Concept State Significant Development Application – SSD 18_9579 Crows Nest Overstation Development - Submission

I strongly object to the above application for the reasons outlined below:

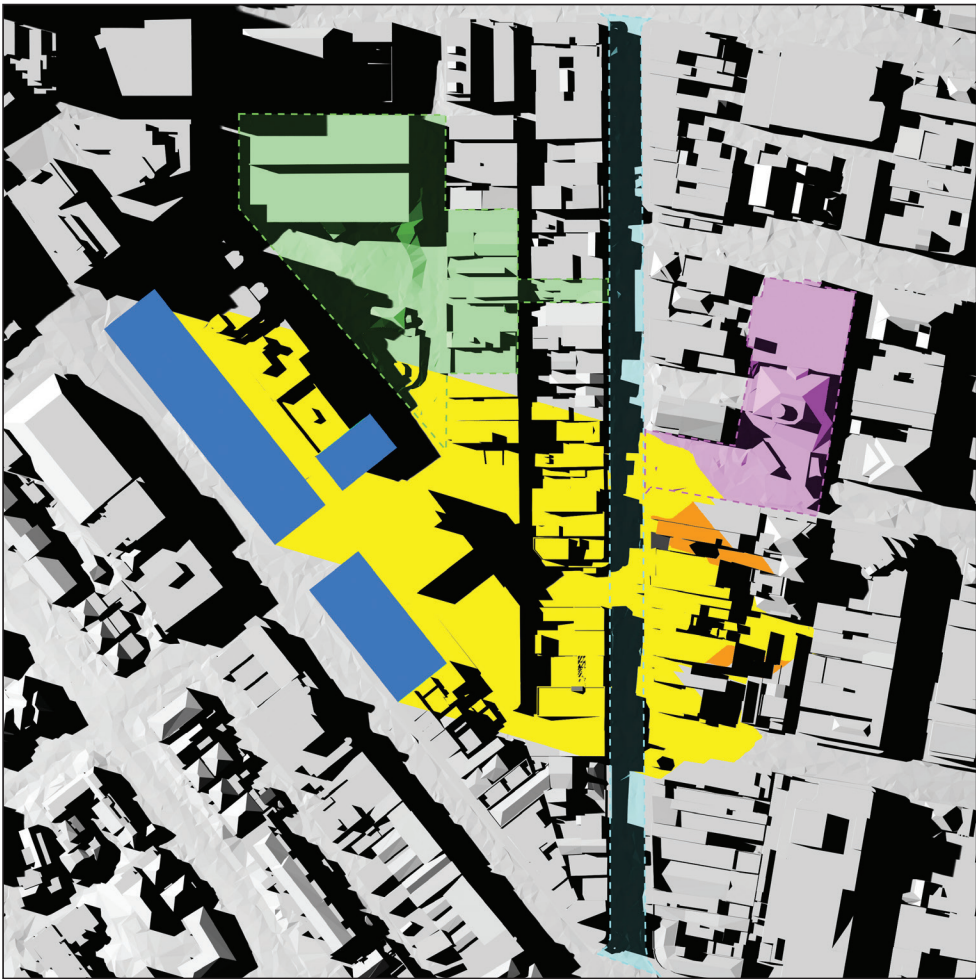
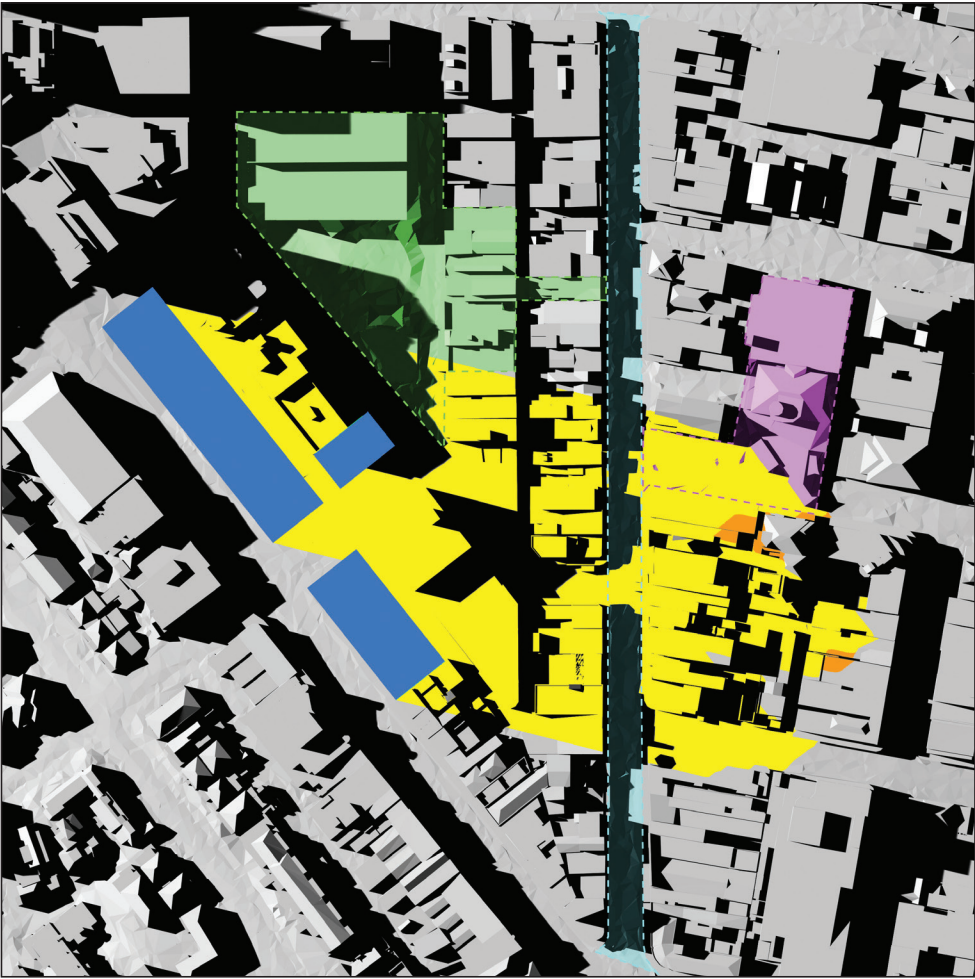
- I object to the overshadowing of Nicholson Street, Hume Street Park, Willoughby Road and Ernest Place in particular year-round, not just between 9.00 am and 3.00 pm.
